January 9, 2018

**RE: Titan Presbyterian East Block – Sector Plan Map Amendment and Site Plan for Building Permit  
Project #1011115, 16EPC-40083/40084**

The purpose of this letter is to explain how we have addressed Conditions of Approval for the Sector Plan Map Amendment and the Site Development Plan for Building Permit for this project, located between Central Avenue and Copper Avenue, and Sycamore Street and the future realignment of Spruce Street. The project was approved by the Environmental Planning Commission (EPC) on February 10, 2017.

3 **SYCAMORE STREET SECTION**
 SCALE: 1/8" = 1'-0"

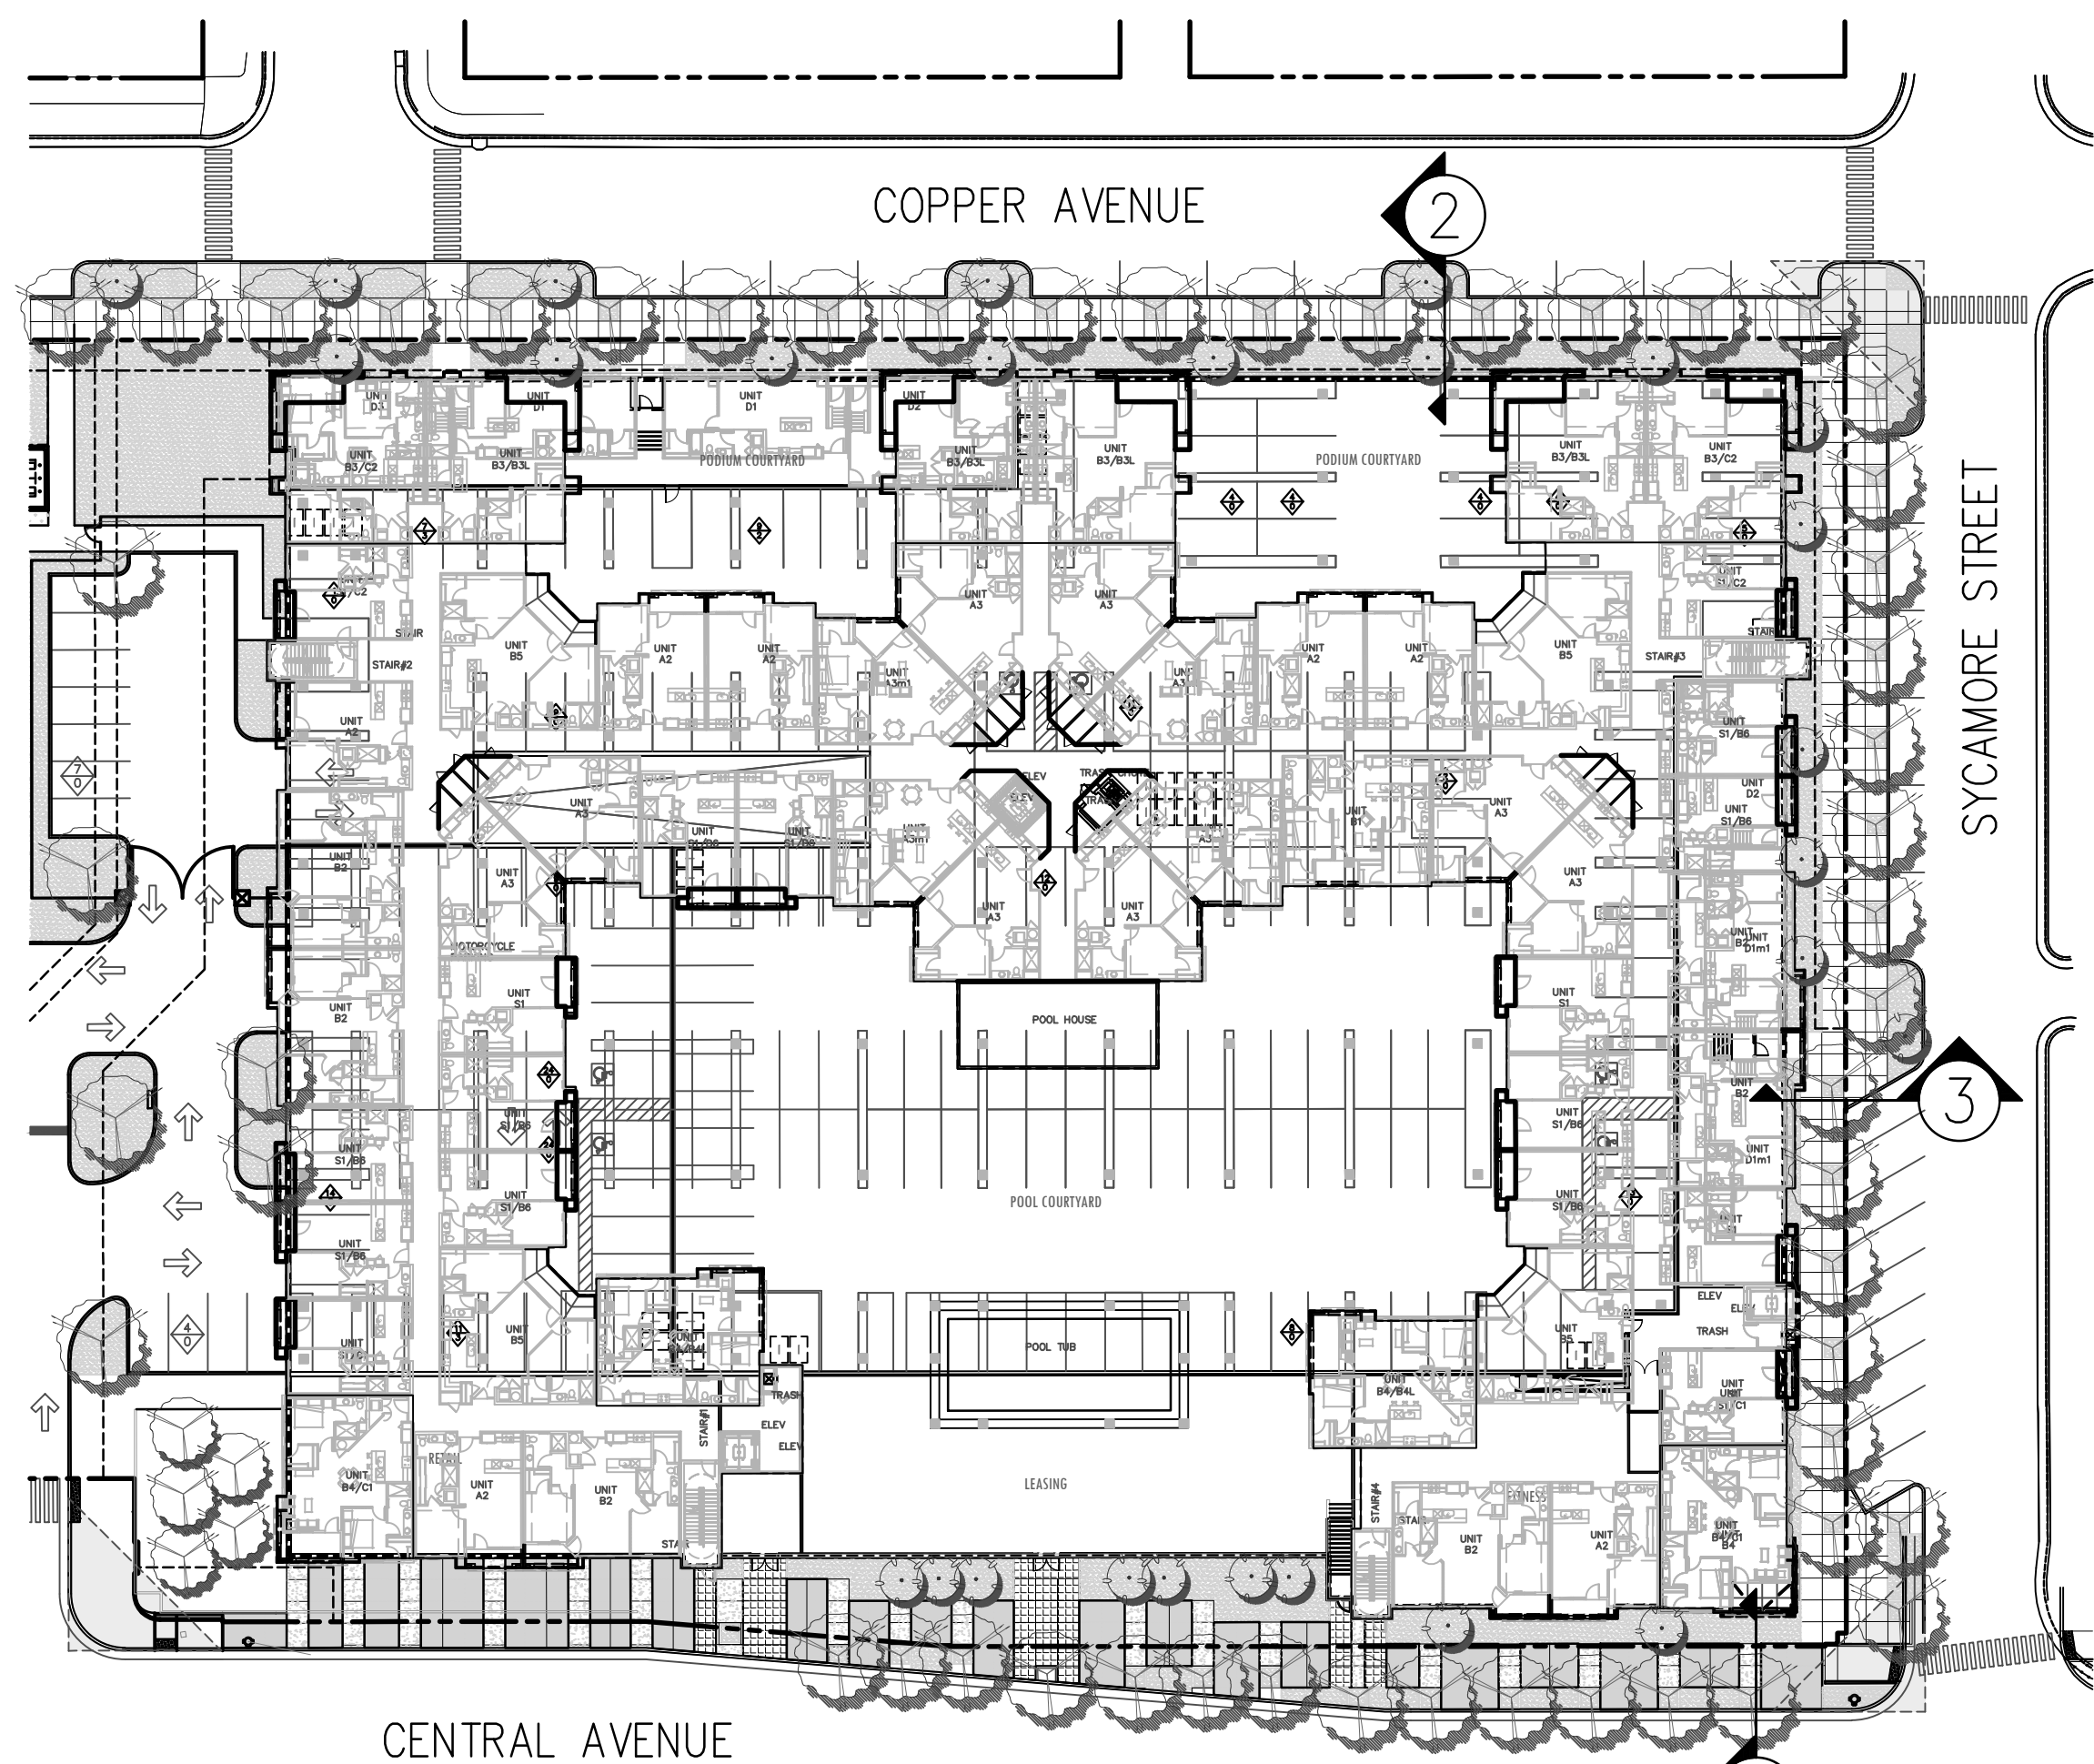
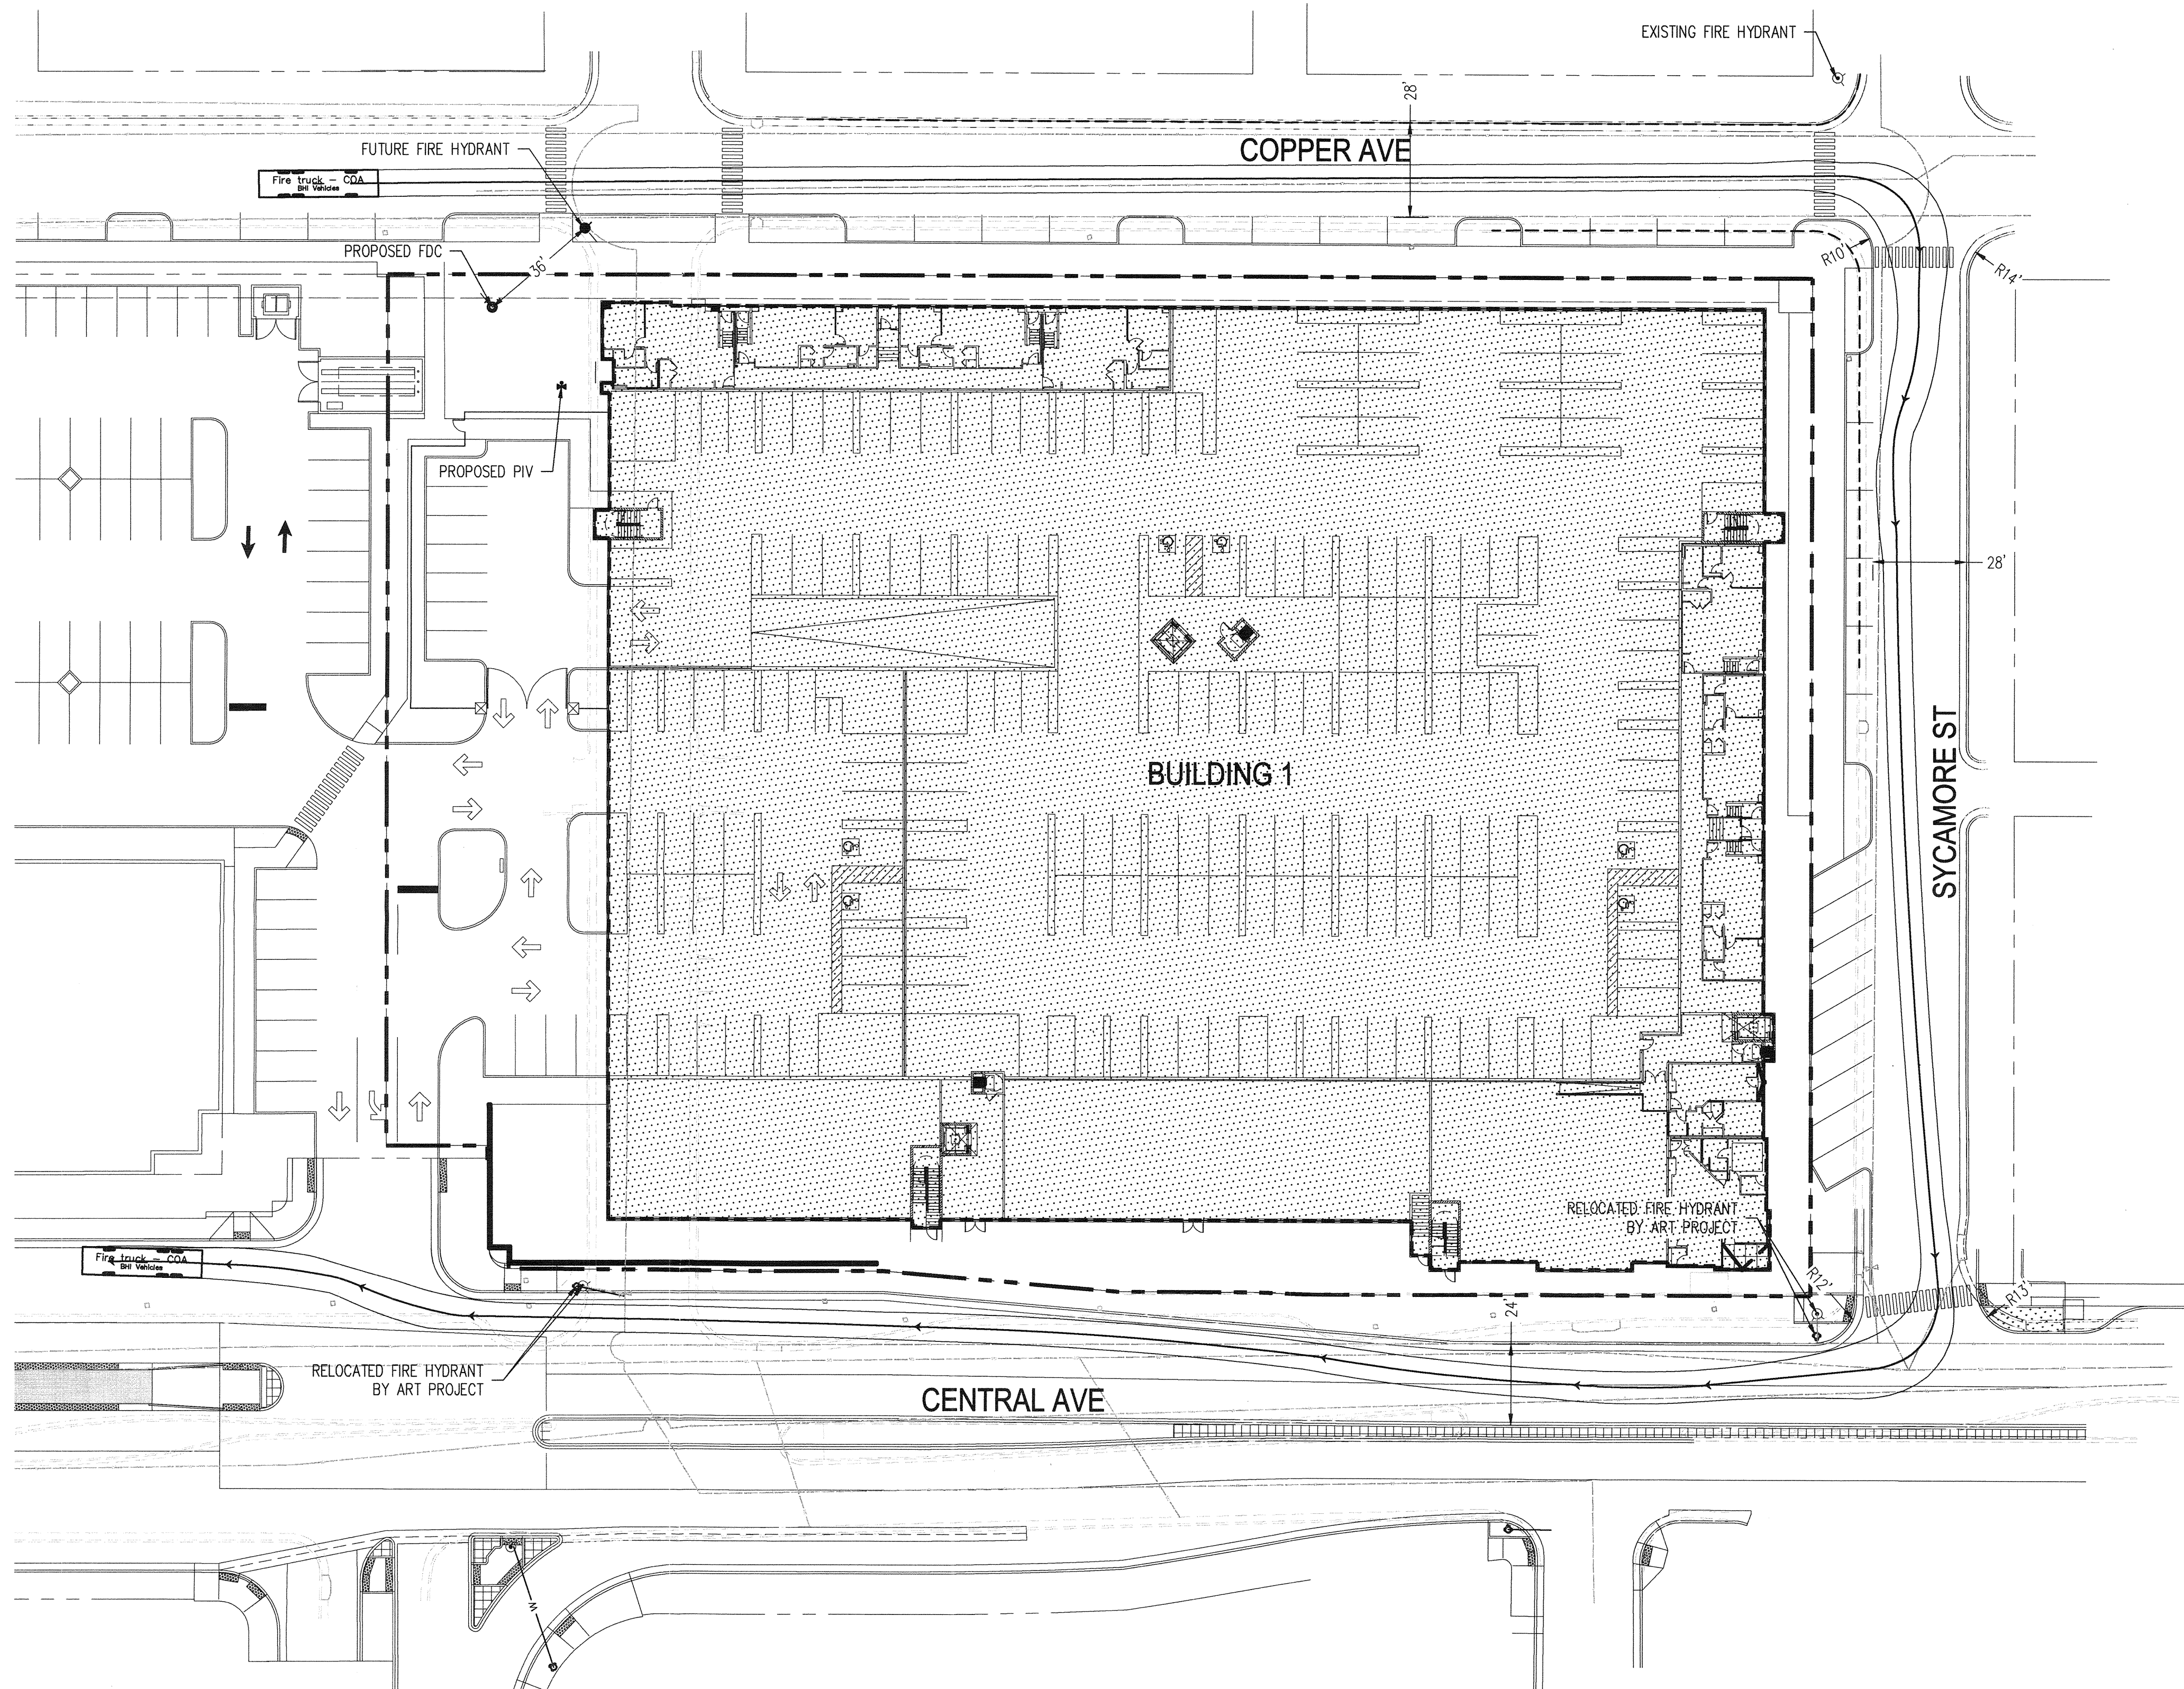
f. On the Pedestrian Realm Exhibits, please update the wording of the LIS Area adjacent to the building to "Frontage Zone" and the LIS Area adjacent to the roadways as "LIS and Edge Zone."

*The wording on the Pedestrian Realm Exhibits has been updated based on this condition. Please see Pedestrian Real Exhibit, Sheet PED-1.*
